13 July 2026

Our house directly overlooks the proposed southern section of the Botley West Solar Farm.

**Operational Development Plan
Southern Site Area**

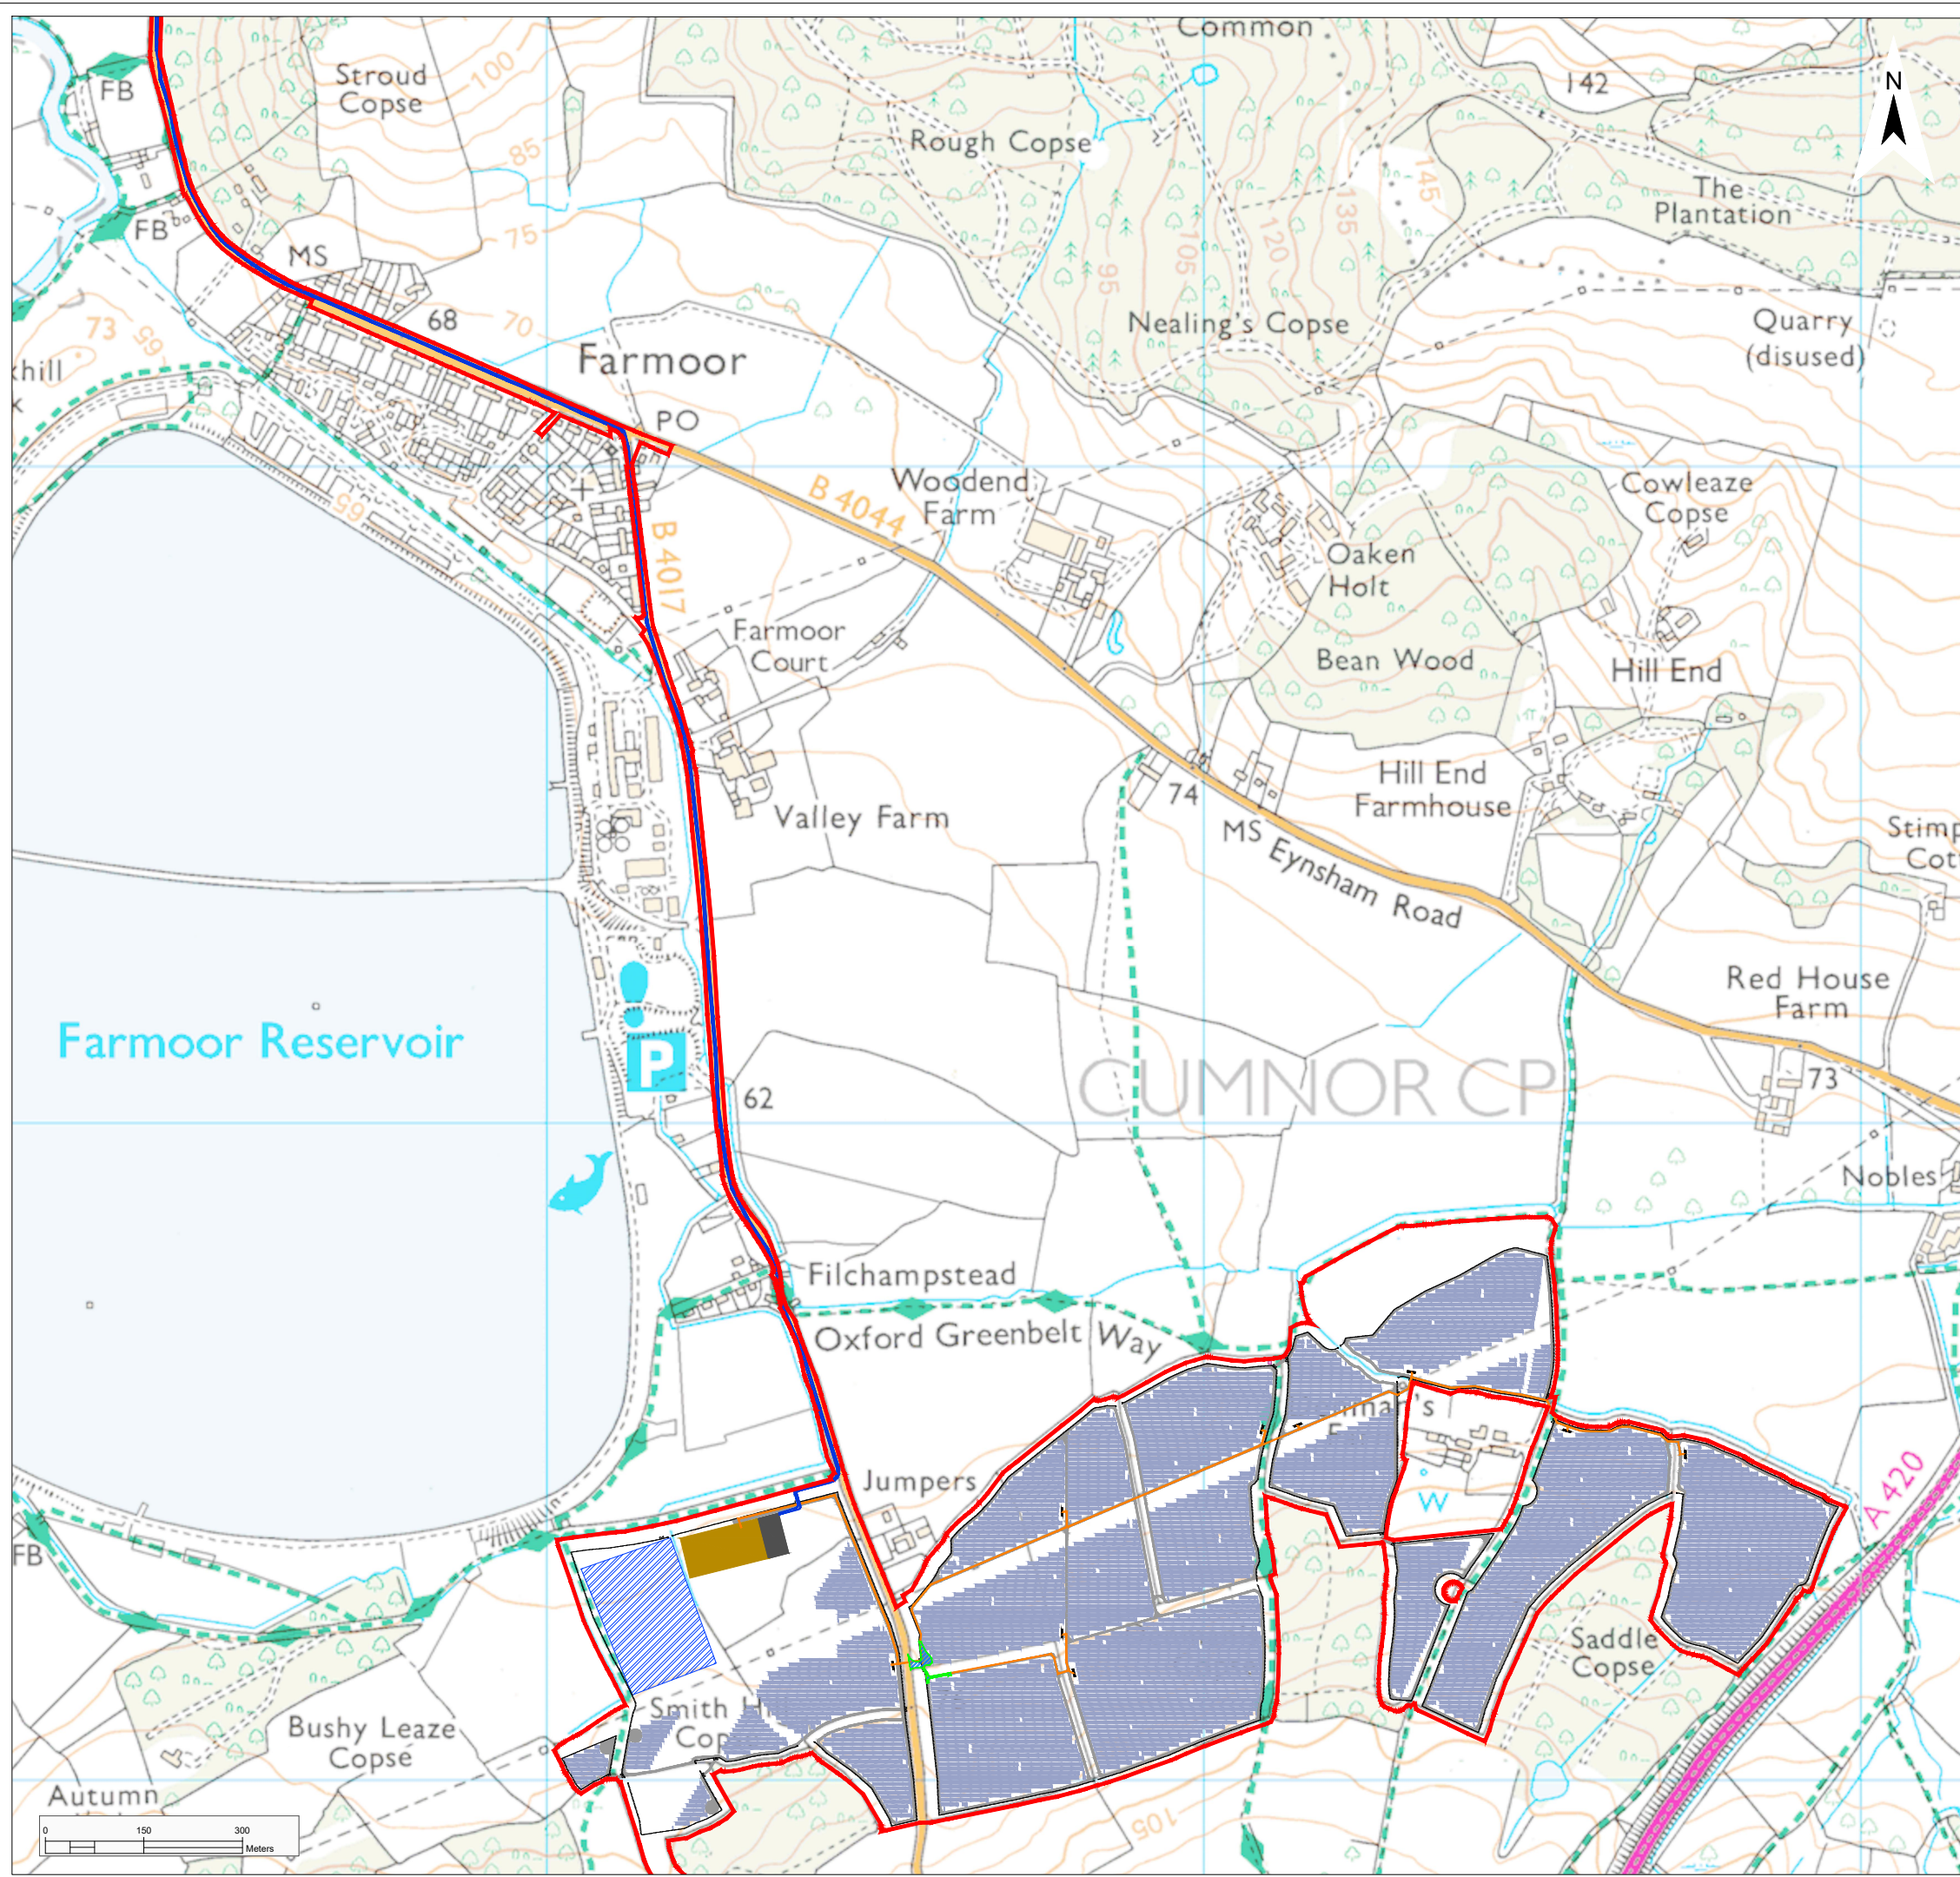
- The existing Residential Visual Amenity Assessment submitted by the Applicant is demonstrably untrue and grossly misrepresents factual reality in respect of our property.

- The Applicant states that the visual impact on our property will be "low / minor / not significant" and that the proposed development "would not form a prominent feature in the view".

- Our property enjoys sweeping, elevated views across the whole of the proposed southern section of the project, both from the garden and all floors of the house.

- The elevated views our property enjoys are not limited to "upper floor windows" as the Applicant erroneously asserts in its submission (without any evidence).

- The proposed development would not be screened from view from our property by any contiguous mature vegetation.
- The proposed development would have a materially adverse impact on the visual amenity of our property.

- The Applicant has proposed no relevant mitigations which would change this.
